Ribble Valley Borough Council
Council Offices
Church Walk,
Clitheroe
Lancashire
BB7 2RA

Phone: 0300 123 6780
Email: developeras@lancashire.gov.uk
Your ref: 3/2025/0496
Our ref: 3/2025/0496/HDC/KW
Date: 03 October 2025

Location: 18 Hornby Road Longridge Preston PR3 3RE
Proposal: Demolition of rear lean-to extension and garage. Proposed single storey side and rear extensions to form garage, wc, utility and kitchen area.
Grid Ref: 360701 437563

DRAWING TITLE: PROPOSED SITE PLAN
DRAWING NUMBER: 0293 - 2000

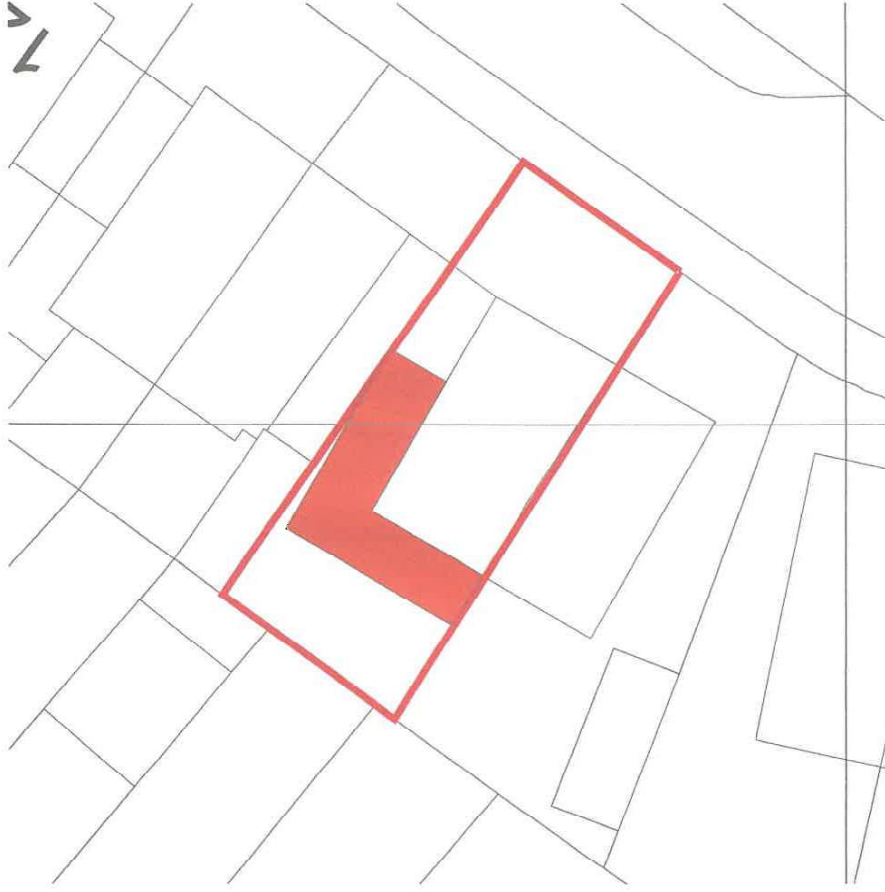
The dwelling is currently served by 2 off street parking spaces within the driveway and an additional existing garage. The proposal will result in the removal of off street parking provisions at the side of the dwelling alongside the existing garage.

The proposal will result in one off-street parking space being retained; as such the LHA expect an additional parking space to be created so that the dwelling can continue to be

served by at least 2 off street parking spaces. Therefore, the LHA requests that a detailed dimensional plan showing at least 2 off-street parking spaces within the boundaries of the site be provided.
